One Earth Solar Farm

**Volume 8.0: Statement of Commonality and Statements of
Common Ground
Draft Statement of Common Ground with Lincolnshire County
Council**

EN010159/APP/8.2

July 2025

Revision 02

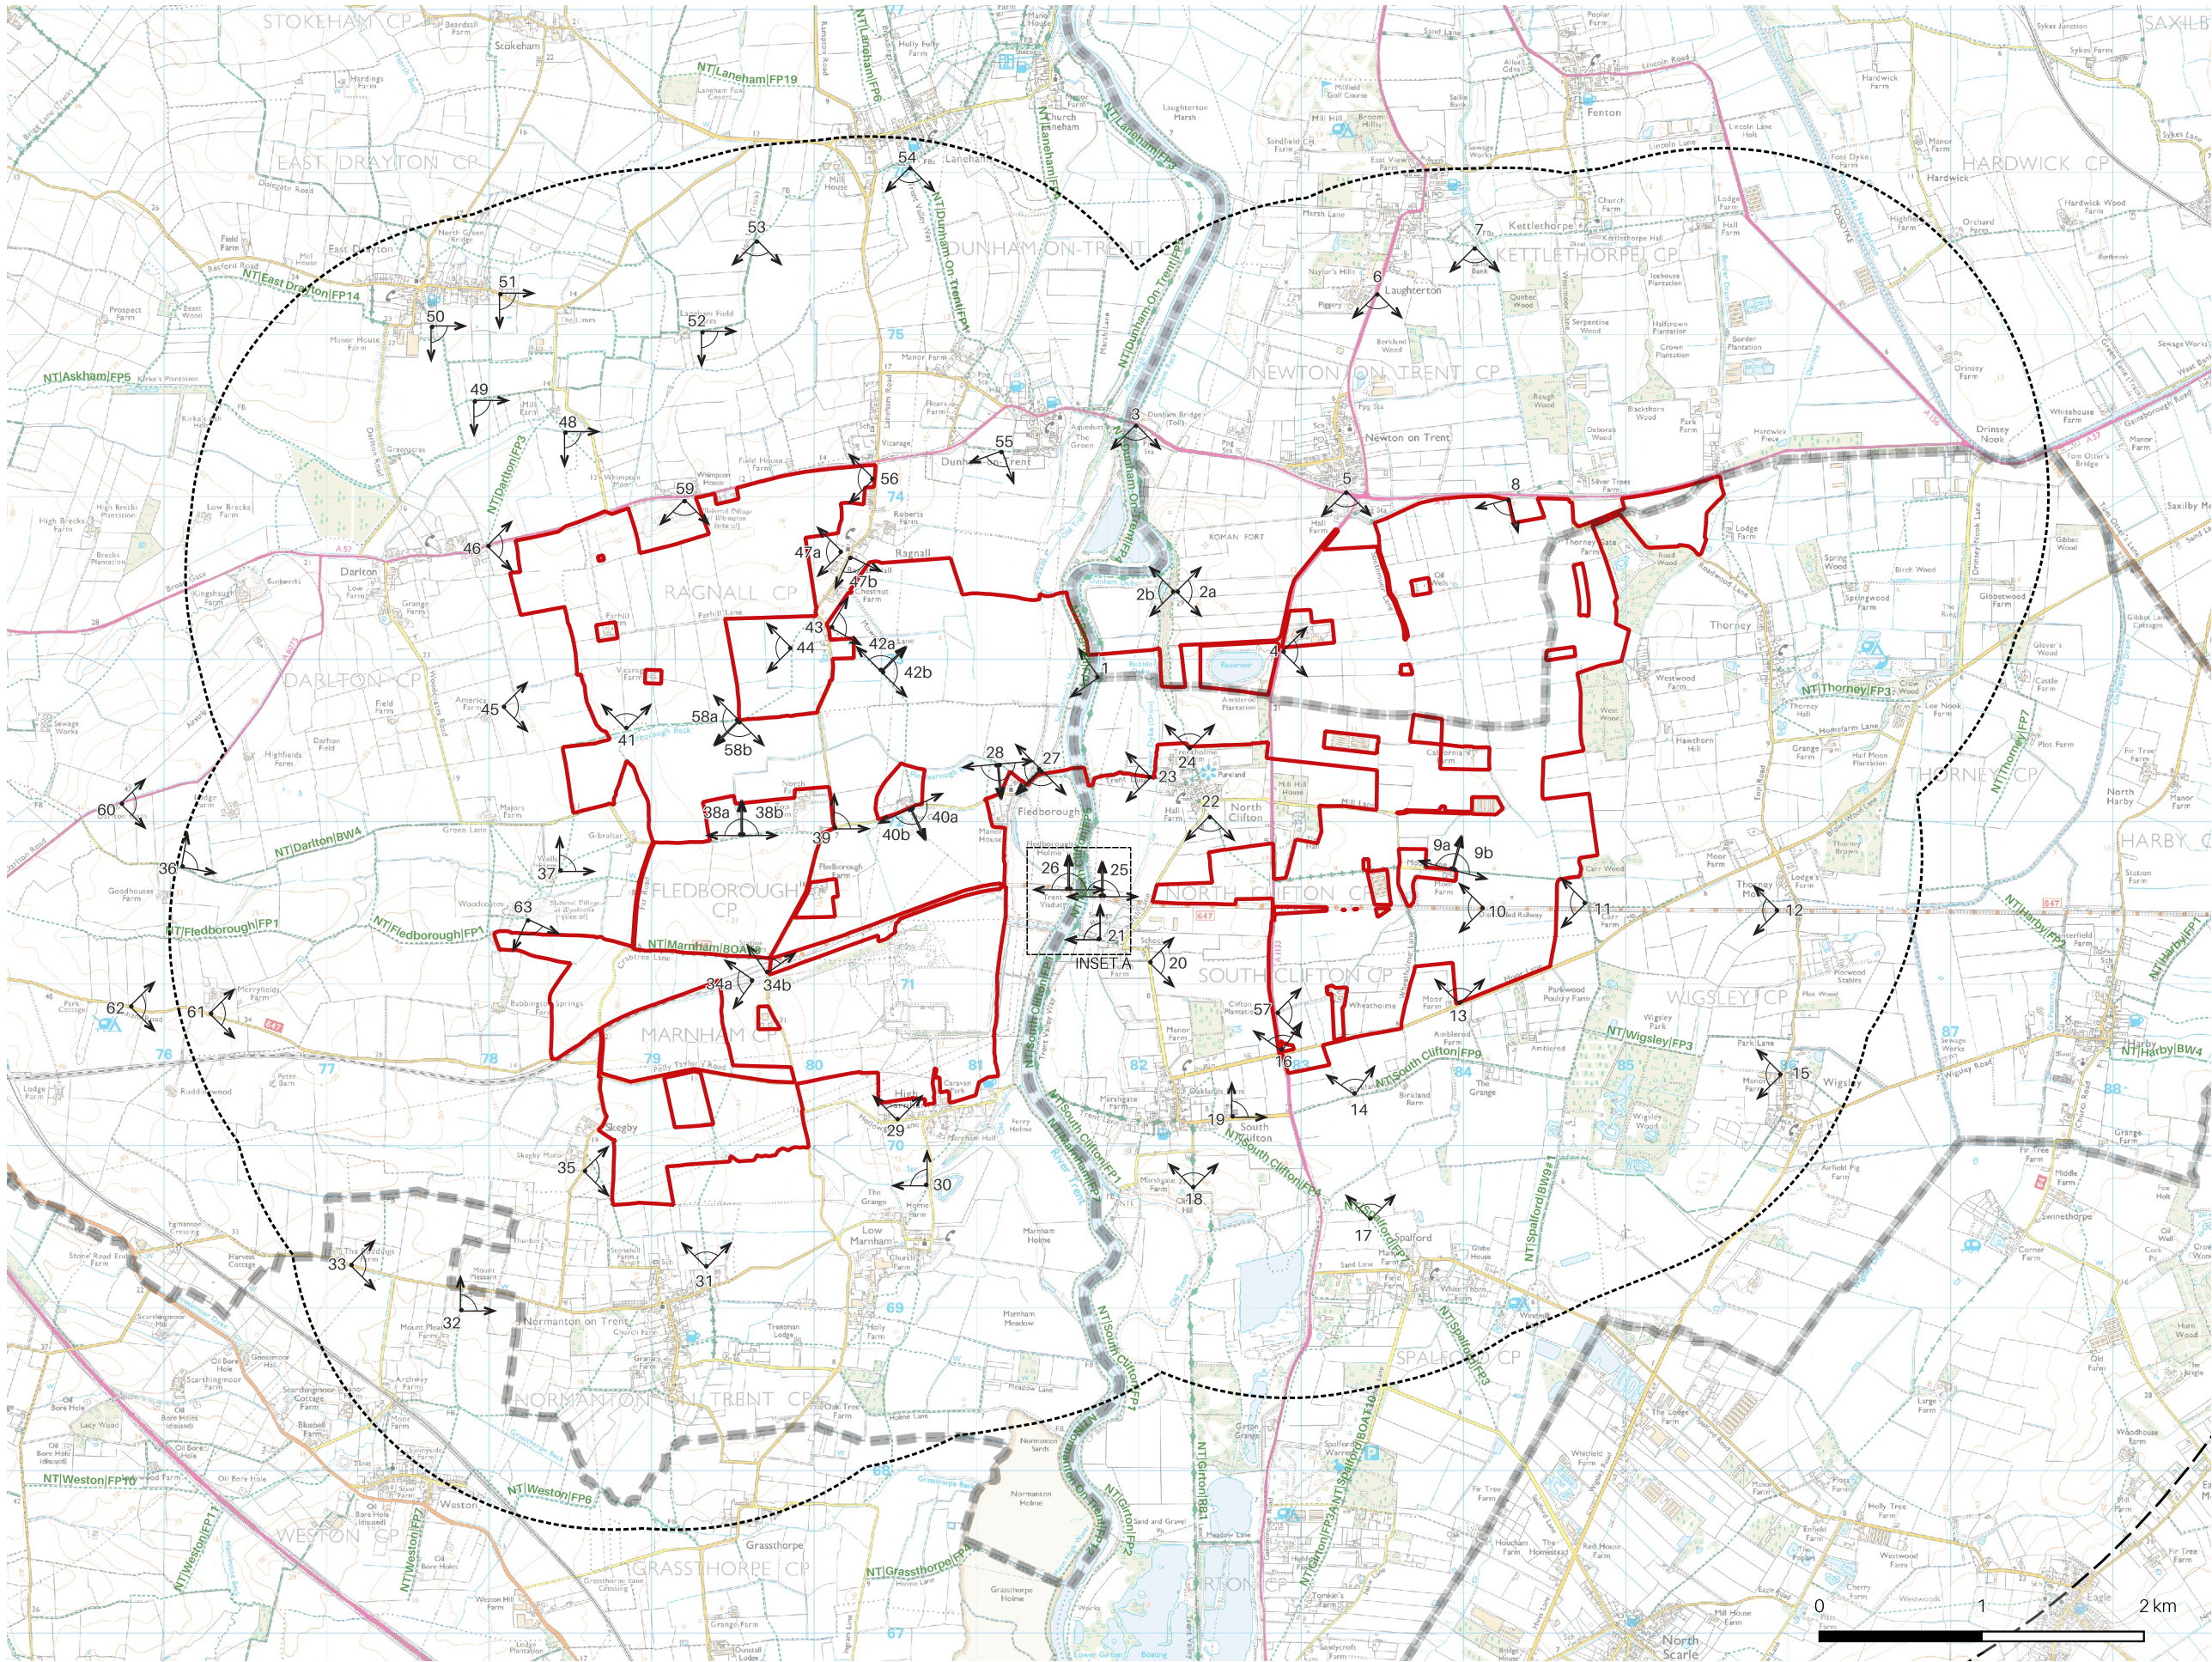
Scope of representative viewpoints	The location of some of the representative viewpoints were questioned and additional viewpoints were suggested following review of the PEIR. No further comments or concerns on the scope of representative viewpoints have been raised.	The scope of representative viewpoints is agreed. The scope of representative viewpoints was updated in the LVIA ES Chapter to include for the suggested additions and refinements.	Agreed

Revision 02

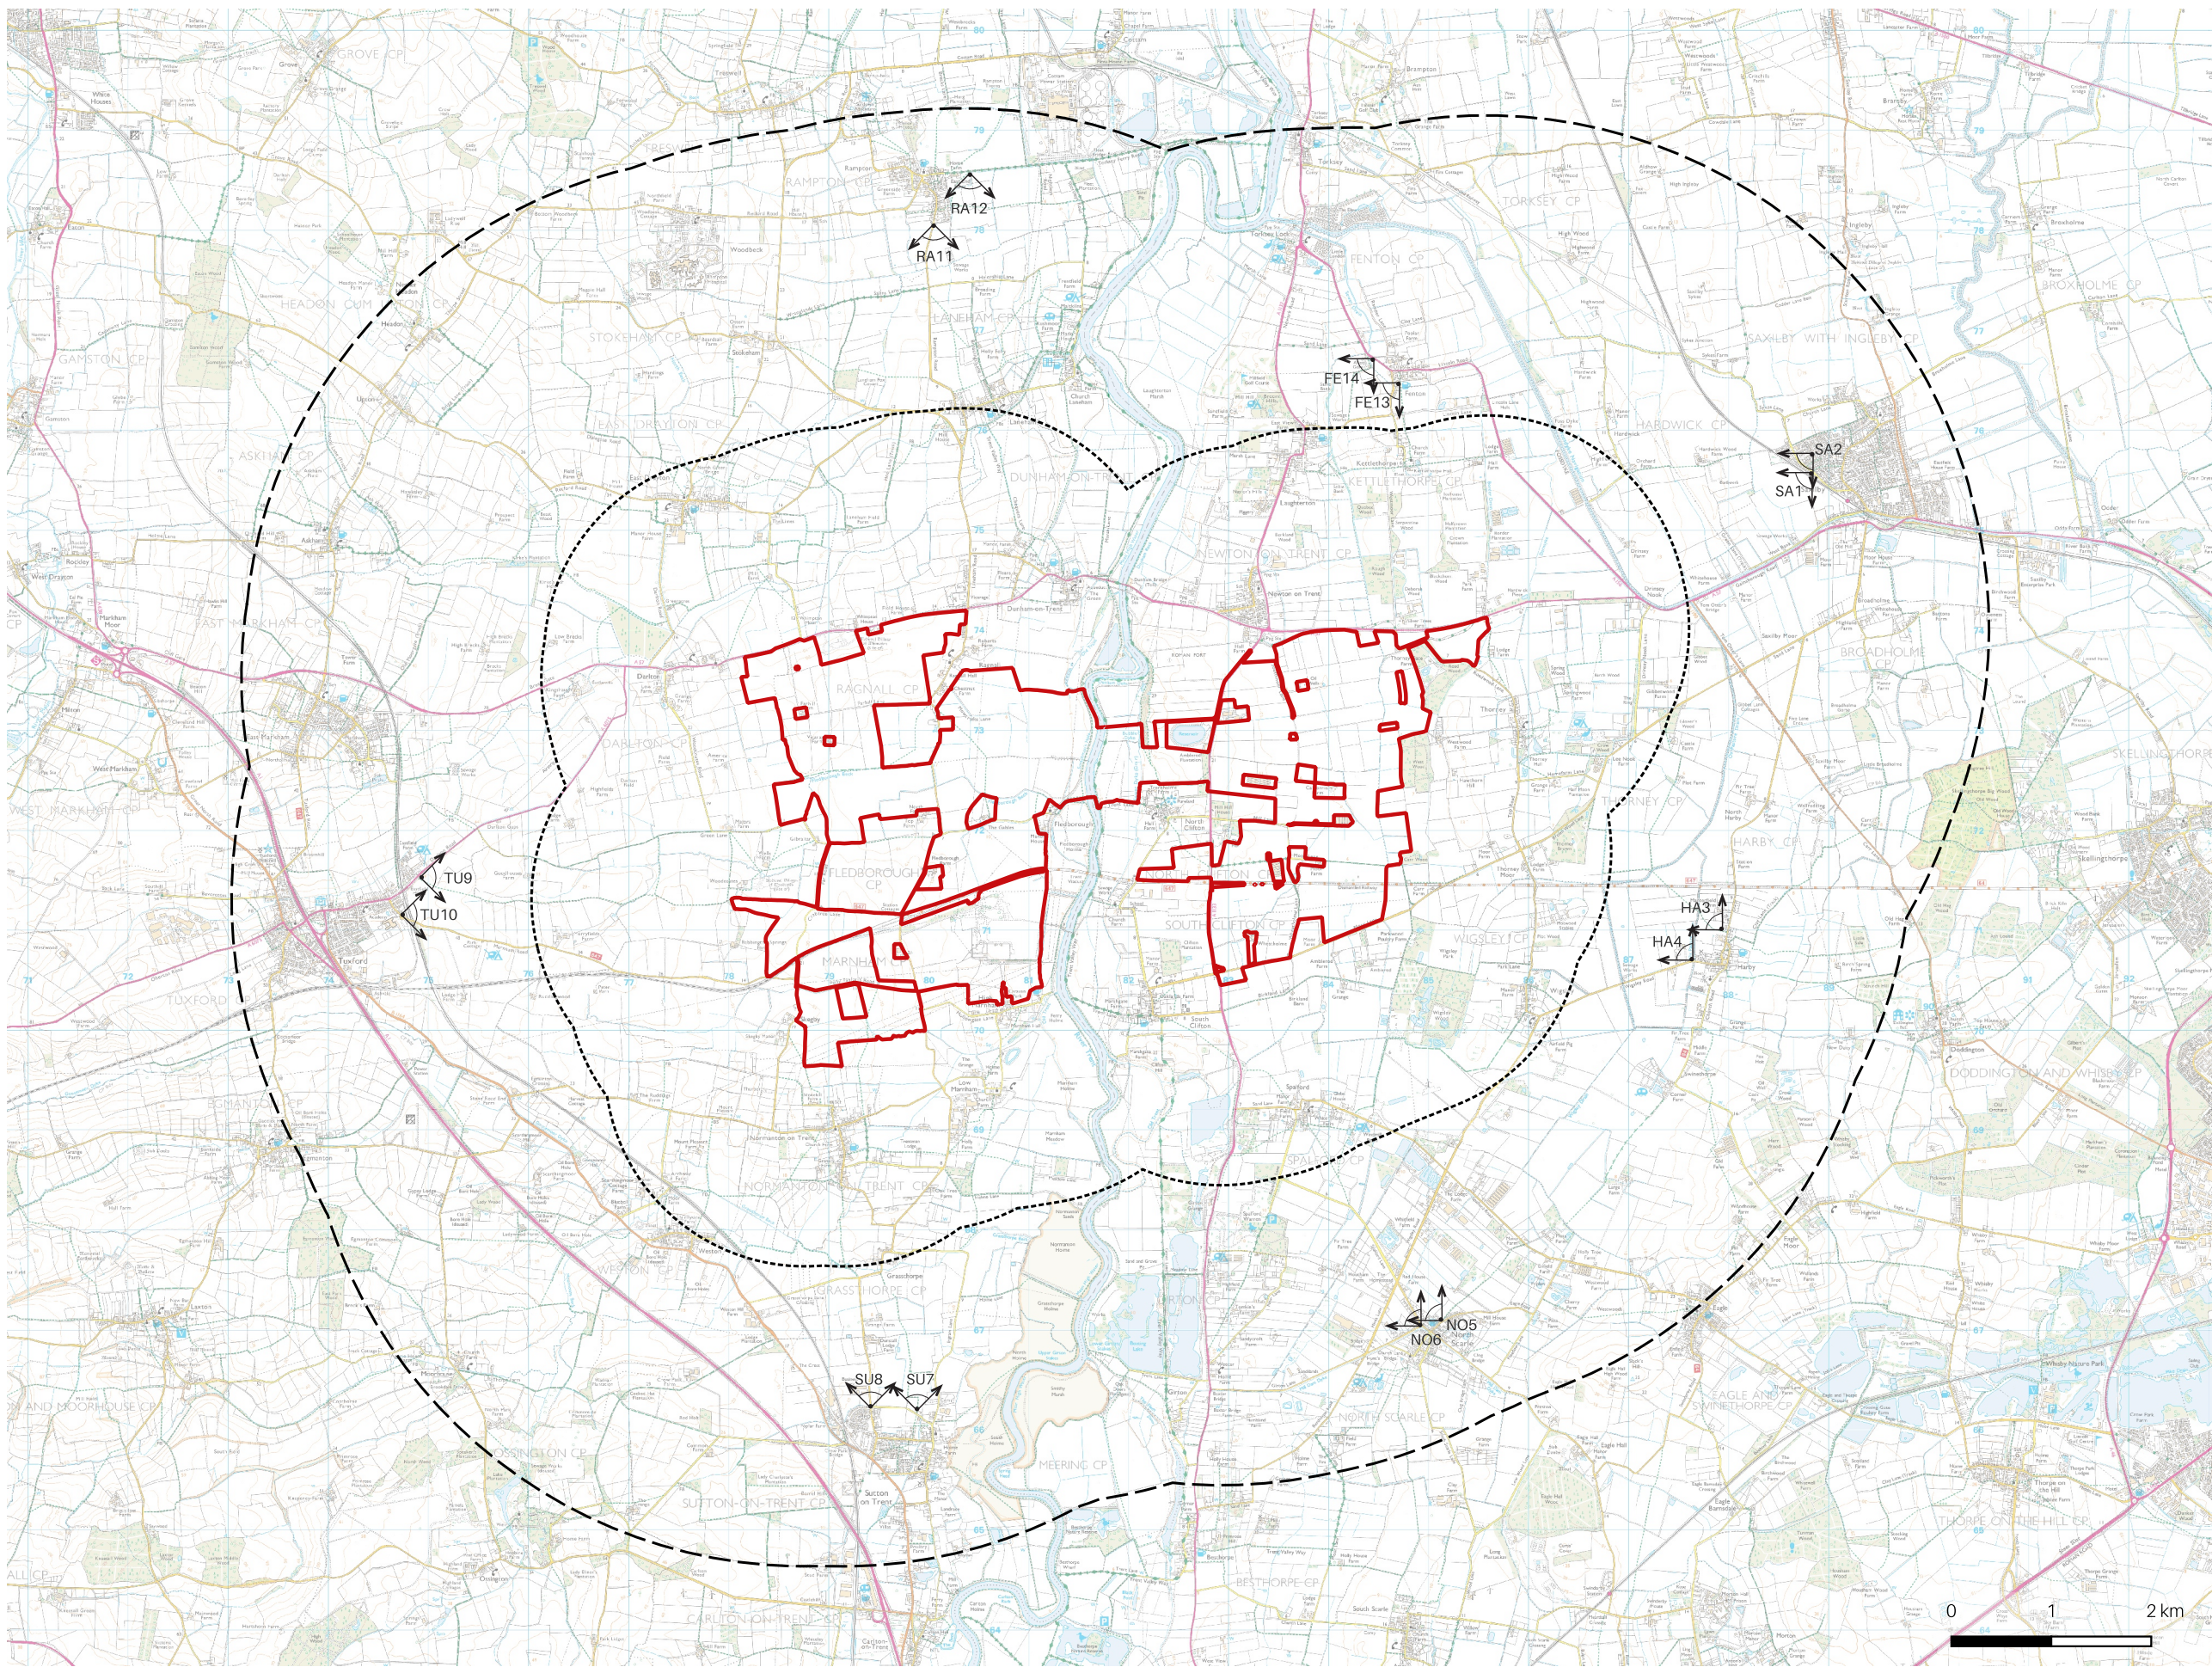
judgement of no significant visibility beyond 2km. AAH Consultants welcomed these photographs but questioned the location of some of them in terms of representativeness of the receptor.		
	Scope of landscape receptors	The inclusion of Thorney as a Local Village Character Area following feedback on the PEIR was welcomed. No further comments or concerns on the scope of landscape receptors have been raised to date.	The scope of landscape receptors is agreed. The scope of landscape receptors was updated in the LVIA ES Chapter to include for the suggested additions and refinements.	Agreed
	Scope of visual receptors	Additional visual receptors were suggested following review of the PEIR. No further comments or concerns on the scope of visual receptors have been raised to date.	The scope of visual receptors is agreed. The scope of visual receptors was updated in the LVIA ES Chapter to include for the suggested additions and refinements.	Agreed
